From: Sue Howell
Sent: 28 February 2019 14:49
To: Planning.Responses
Cc: Michael Eastham
Subject: FW: Planning Consultation on WA/99/18/DOC

Further to submission of revised landscape details contained in dwgs CSA 3823-101-111 Rev B in relation to Condition 9 of this application WA/99/18/DOC I can recommend the following:

APPLICATION NO: WA/99/18/DOC

Site Address: Land East of Tye Lane Walberton Arun

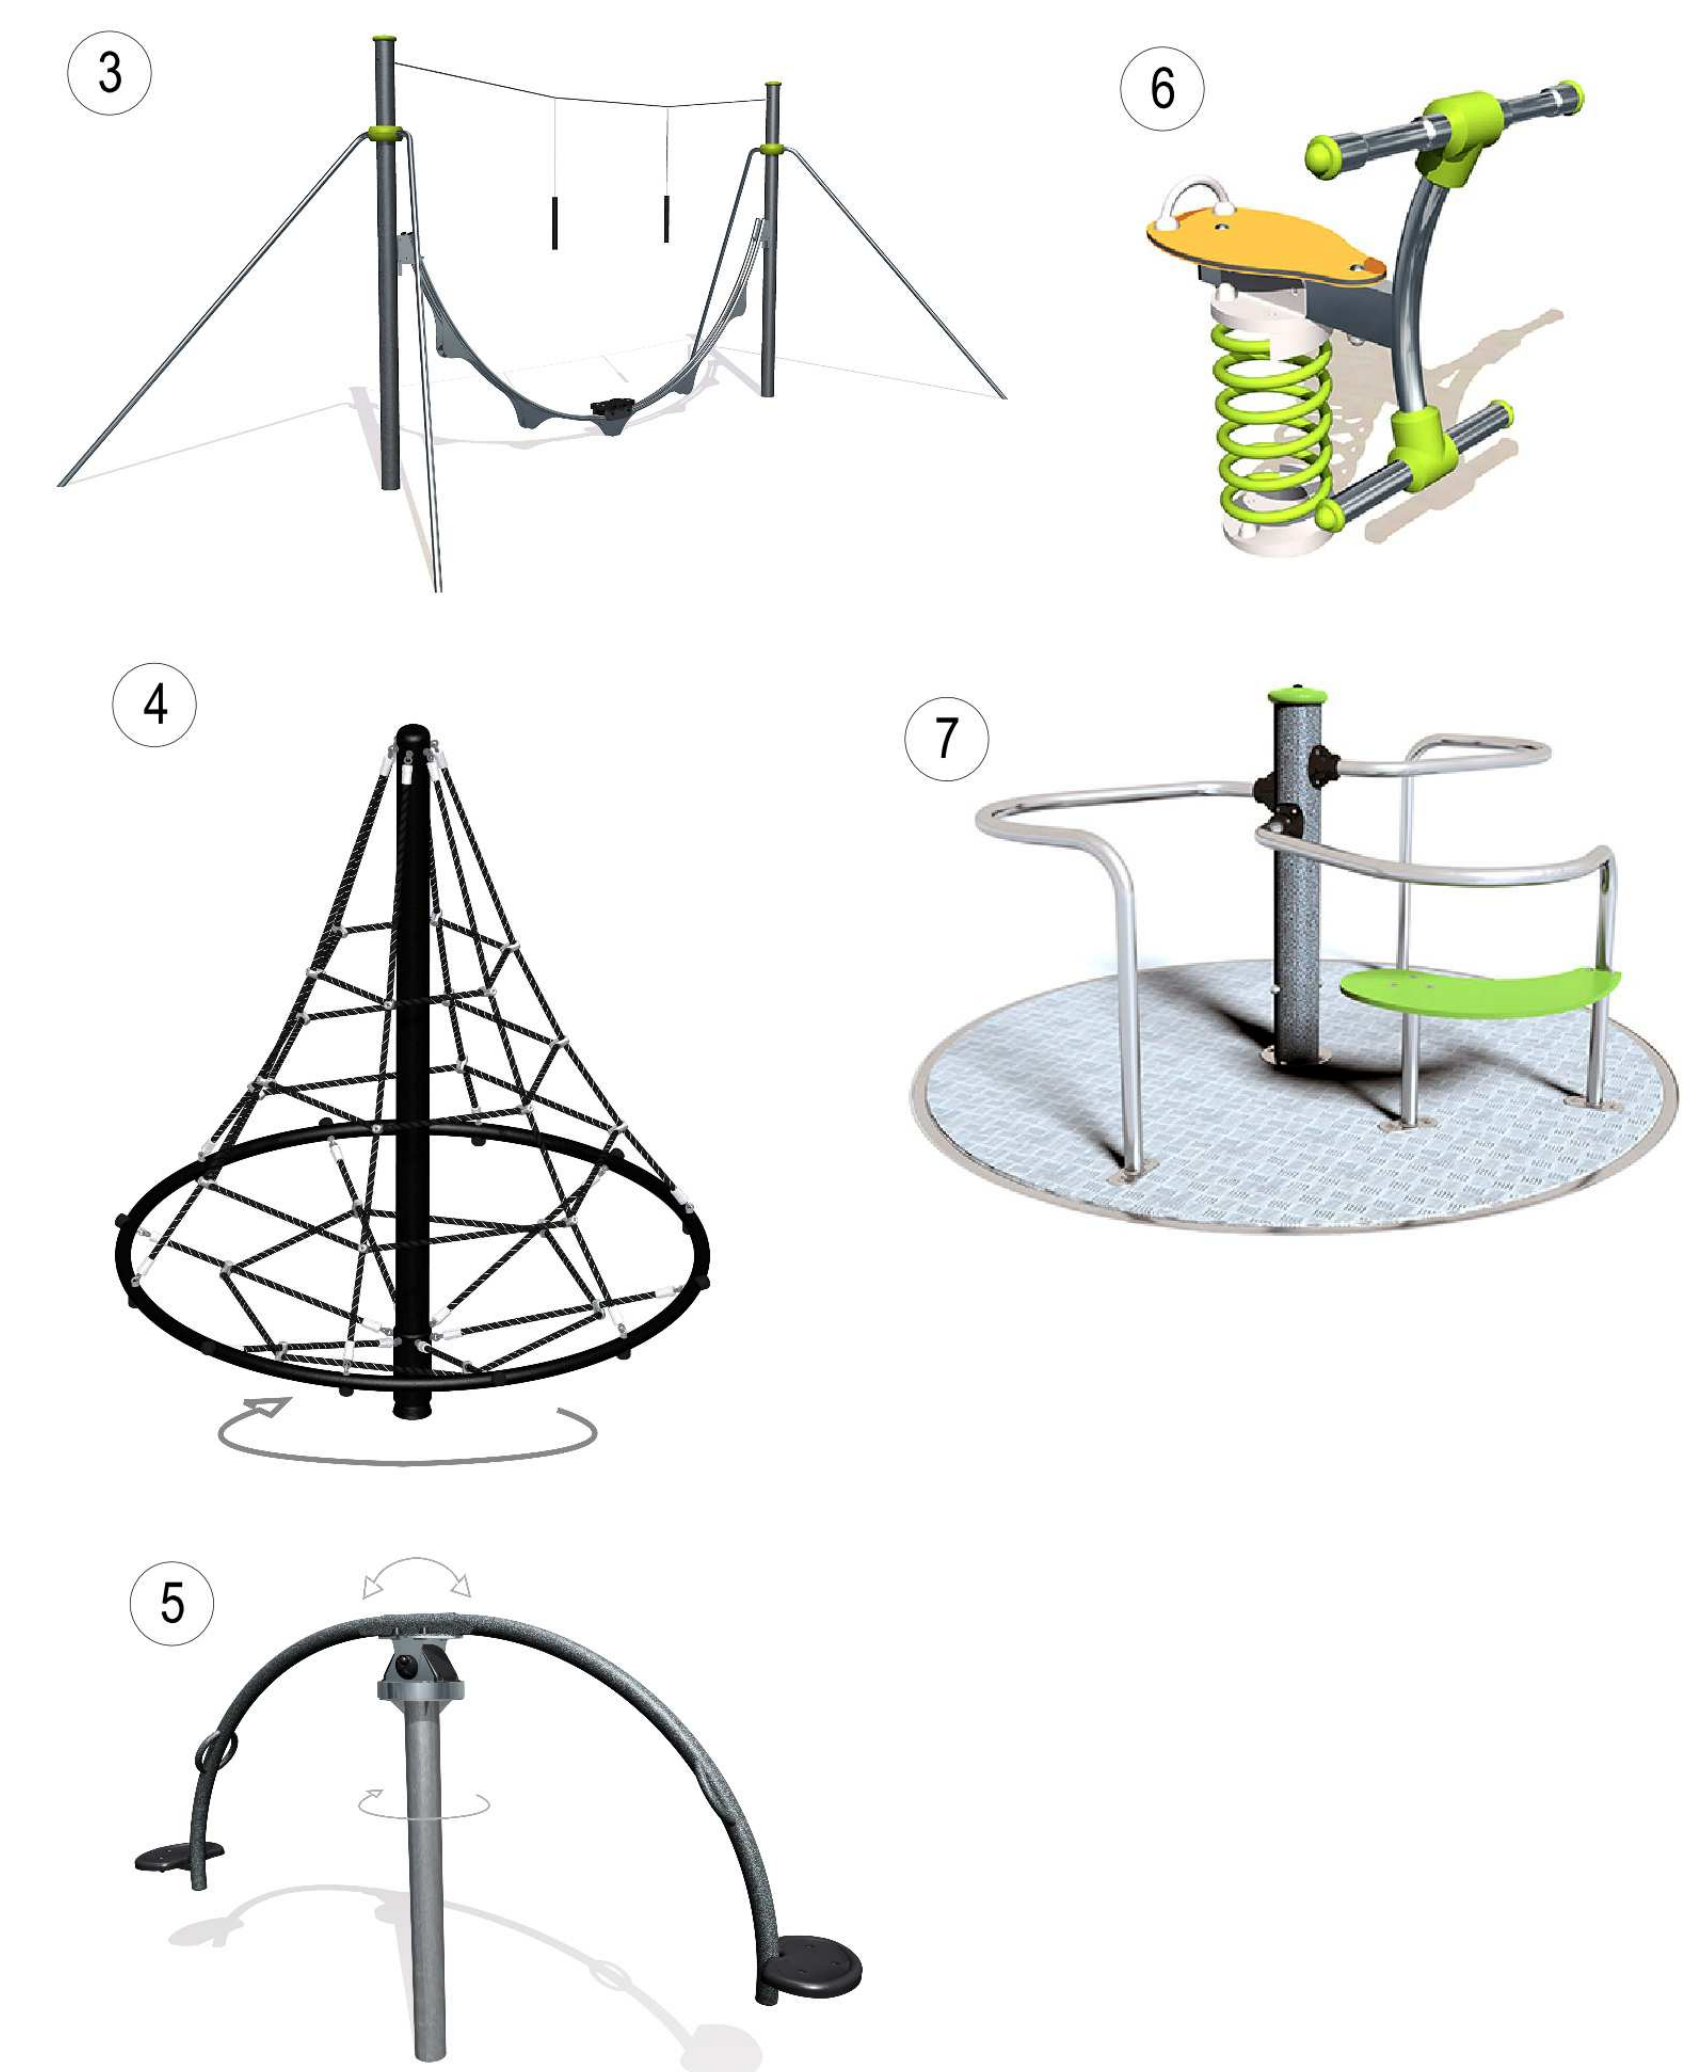
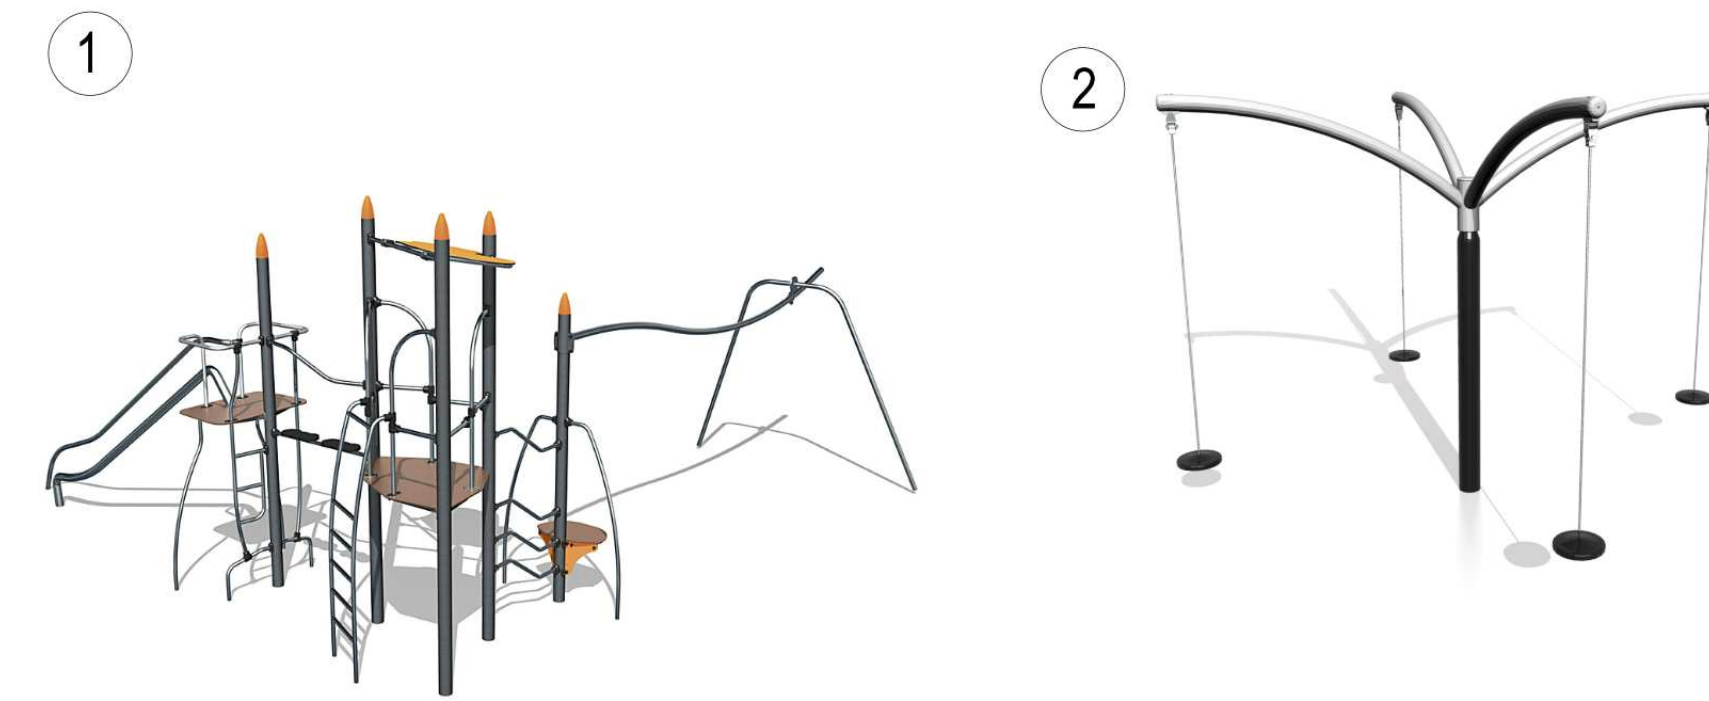
- V. Details of play LAP and LEAP have been provide post revisions and will provide a good and varied play offer, suitable for age range, location and purpose.

- VI. Details of surfacing and signage to play area and footpaths/cycle routes has been detailed and tarmac for these main access routes confirmed.

I would therefore **recommend discharge of Condition 9** landscape details contained in this reserved matters application WA/95/18/RES following outline consent WA/44/17/OUT.
